**From:** Olson, Greg R.  
**Sent:** Friday, June 29, 2012 1:31 PM  
**To:** 'David Soule'  
**Cc:** Olson, Greg R.; Salgado-Fernandez, Nilo E.  
**Subject:** D18/D014D : Out parcels at Lowes on SW corner of Paseo del Norte & San Pedro  
David,

Here are some quick notes on the items I flagged in your Grading & Drainage submittal signed 5/18/12.

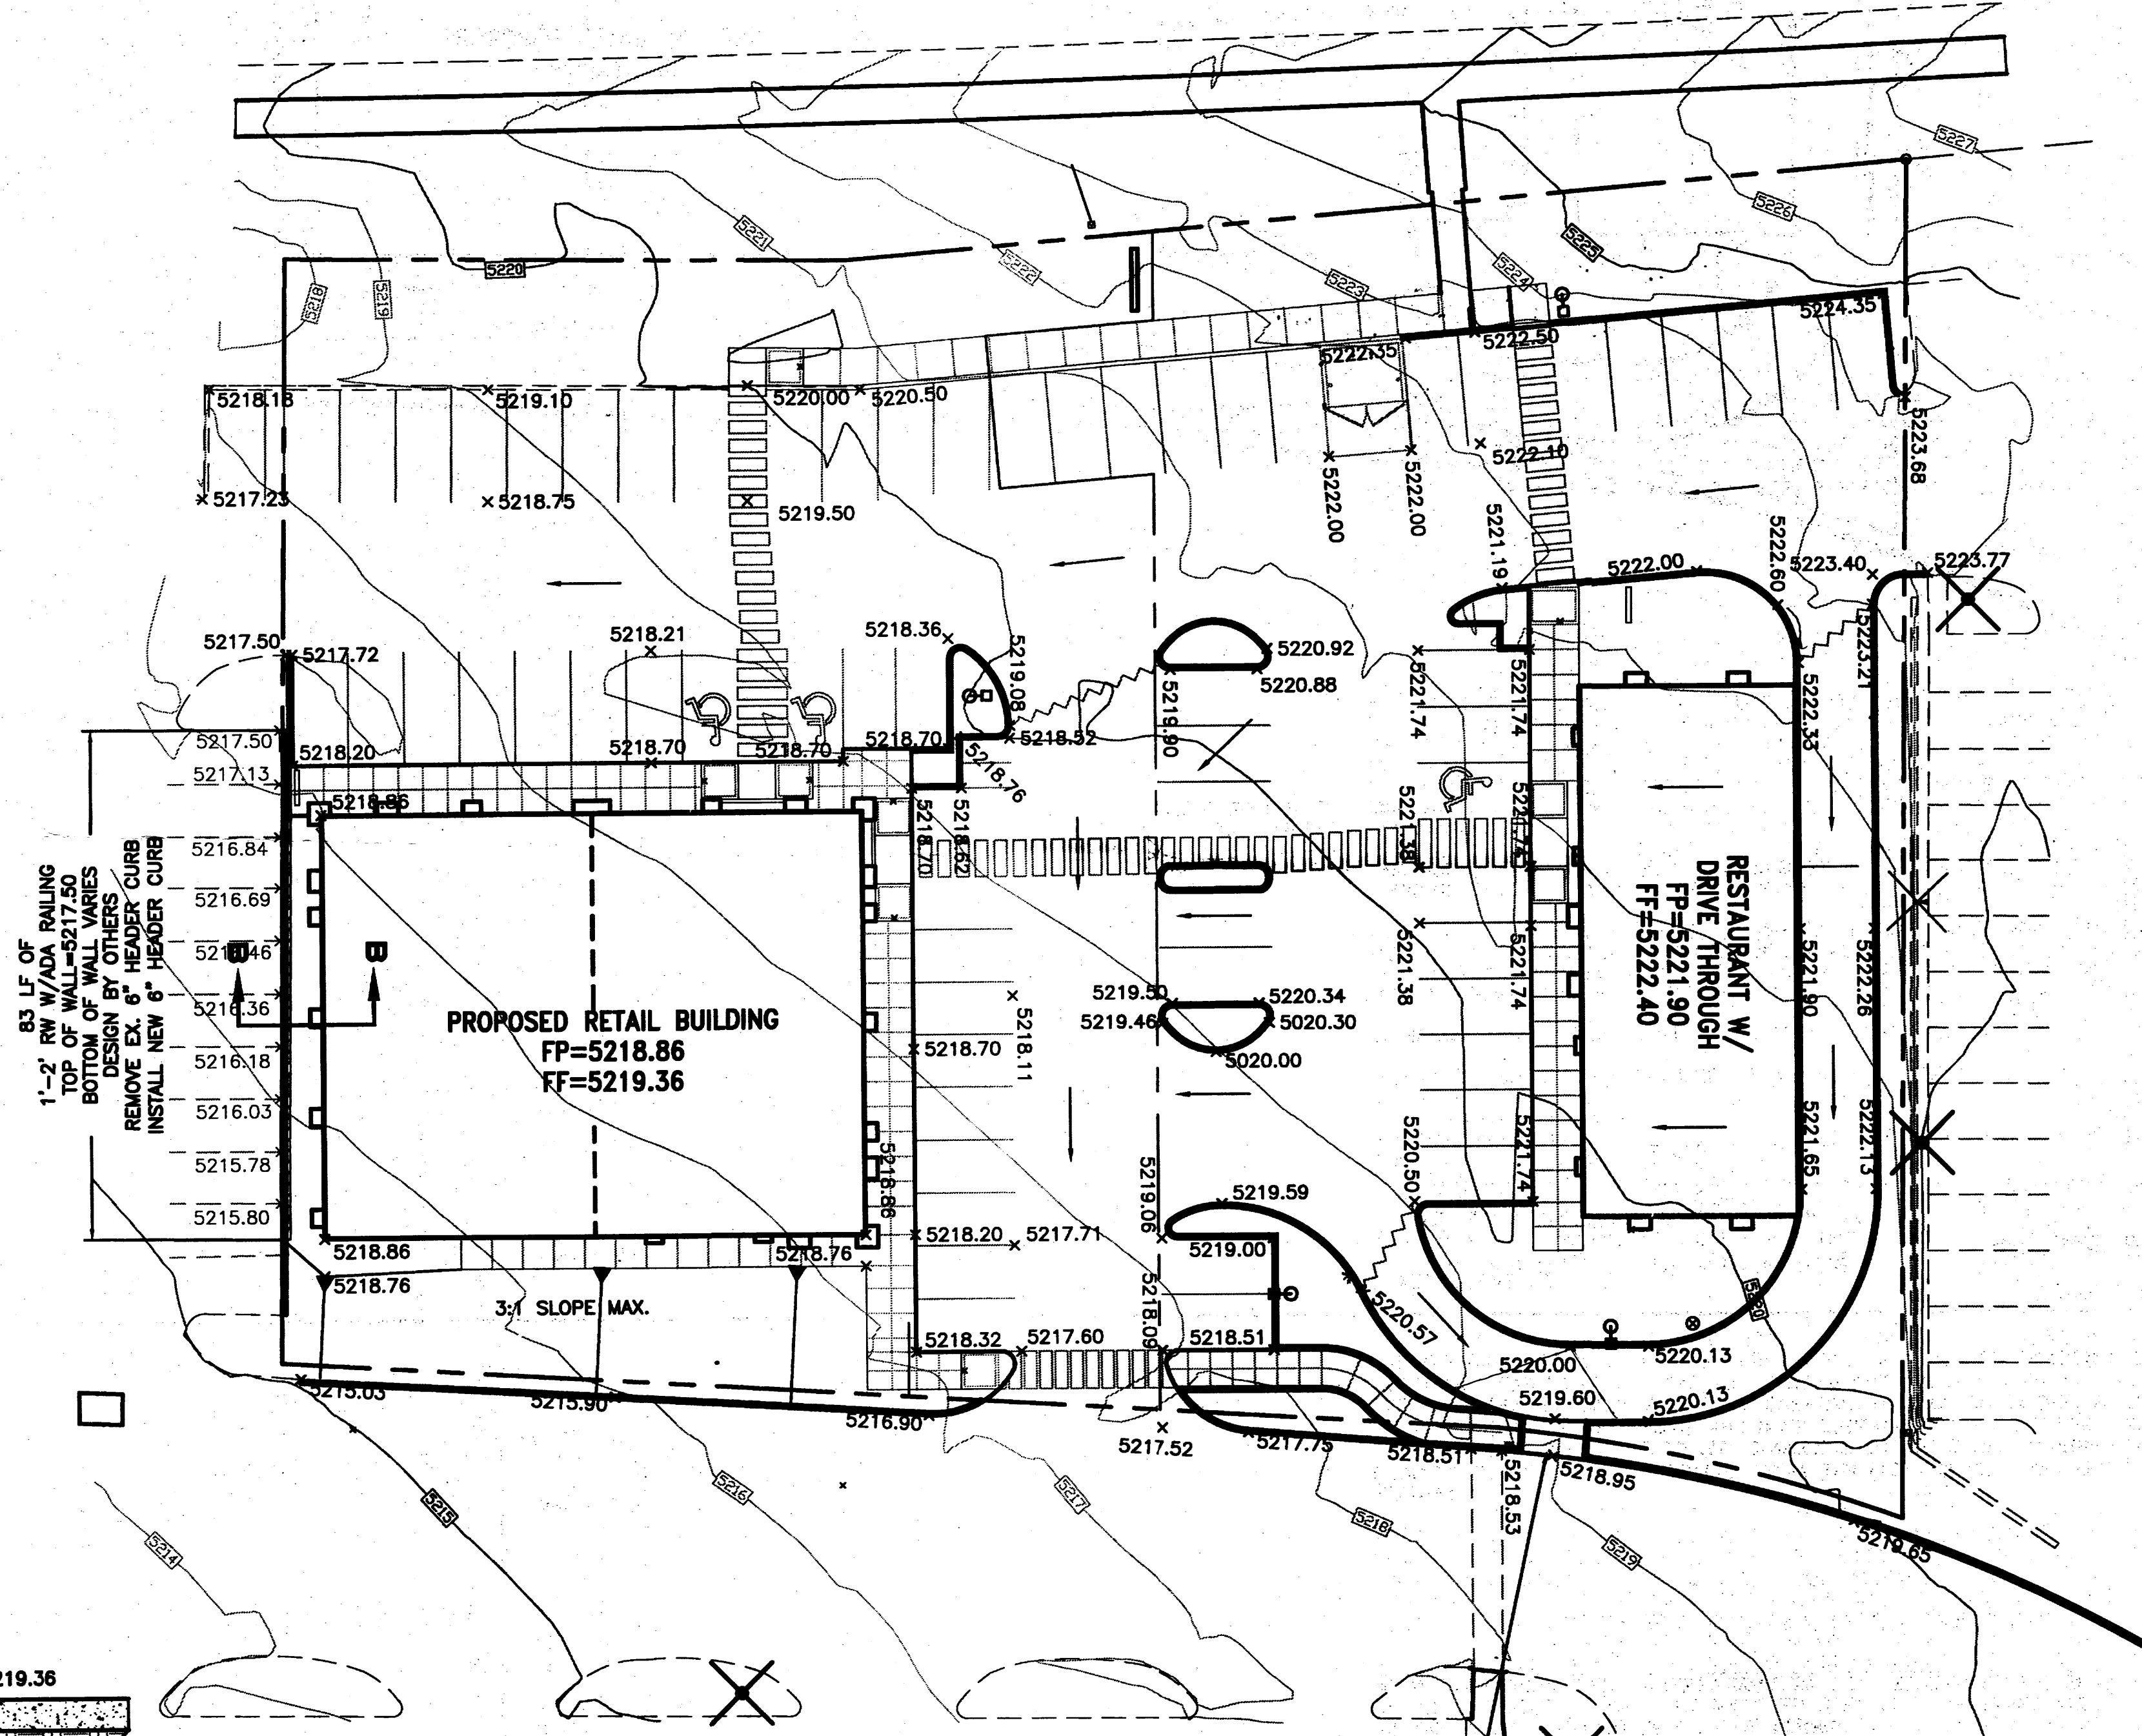
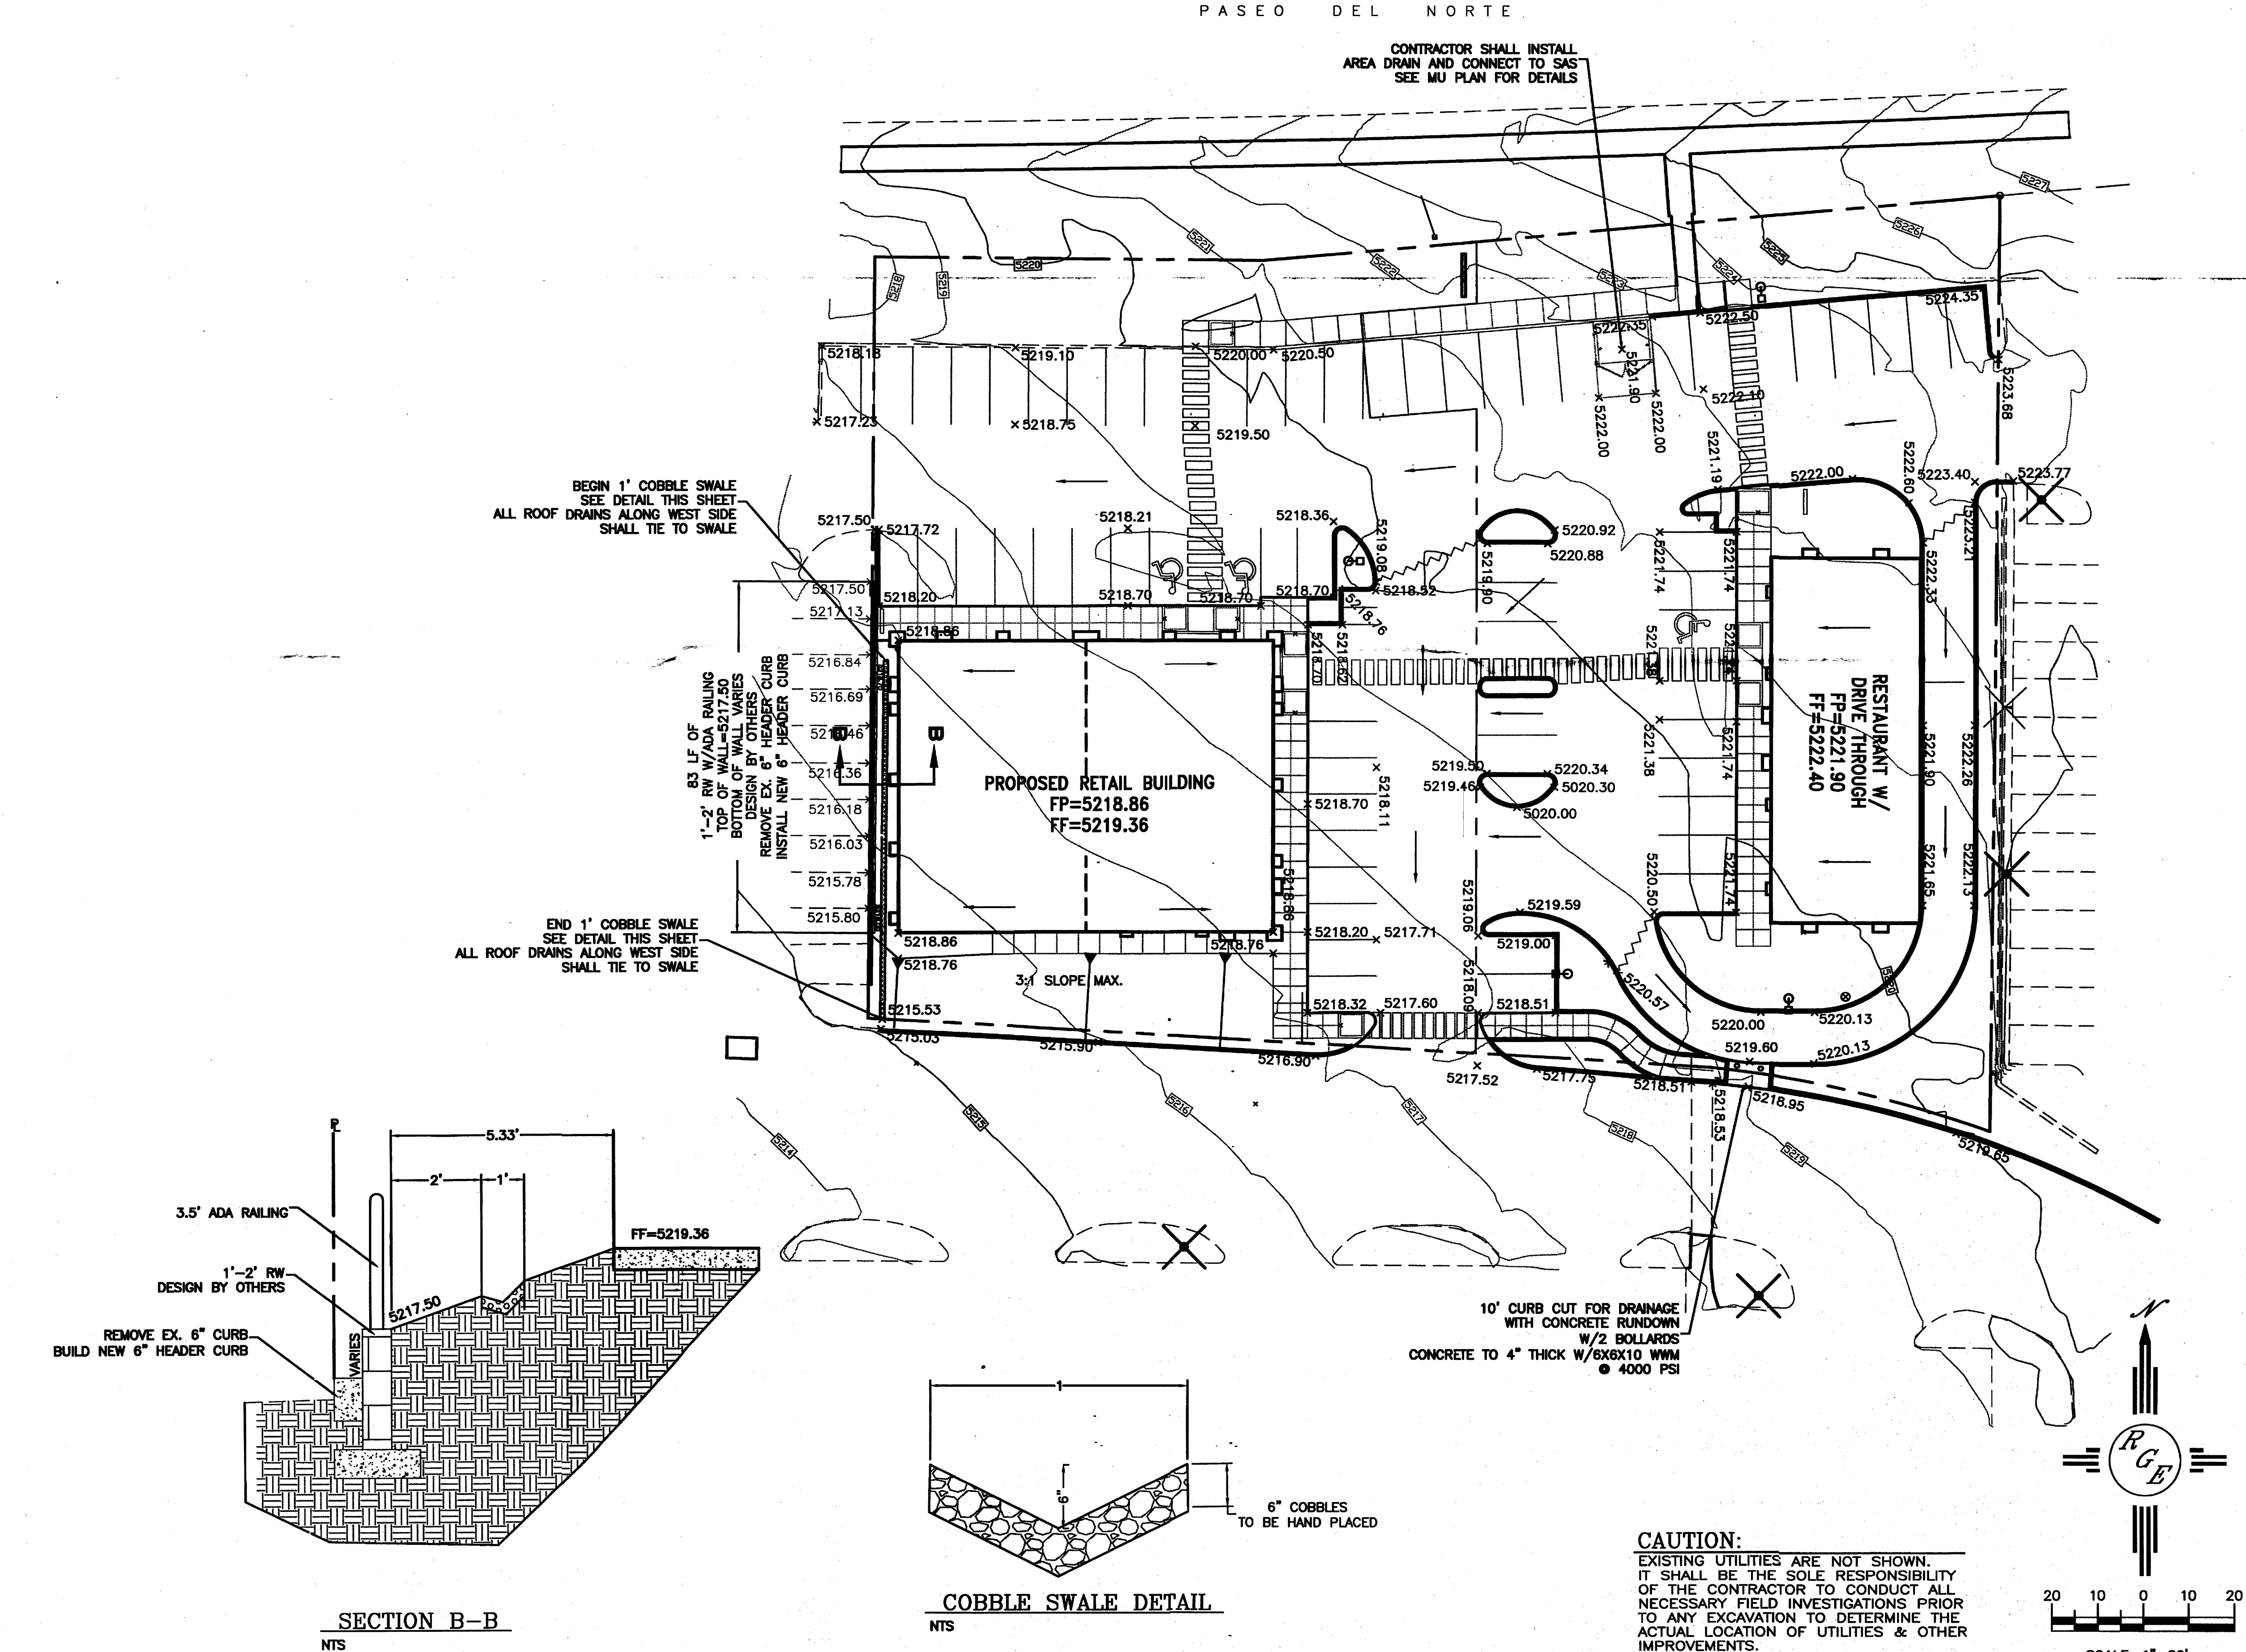
1. **Where does roof runoff go from SW building?** Avoid erosion on the steep side slopes S & W of pad.
2. Per DPM, the Dumpster pad for the restaurant must drain to the Sanitary Sewer.  
**Show this on the plan.**

3. At the 10' rundown south of the restaurant:
  - a. at 10' wide will it become a shortcut to the drive-through?
  - b. The original Lowes site had a N-S pedestrian corridor just west of the restaurant pad. This plan seems to carry that through the site, except at the drive-through. Will it be continuous, and will it be **compatible with the drainage rundown?**
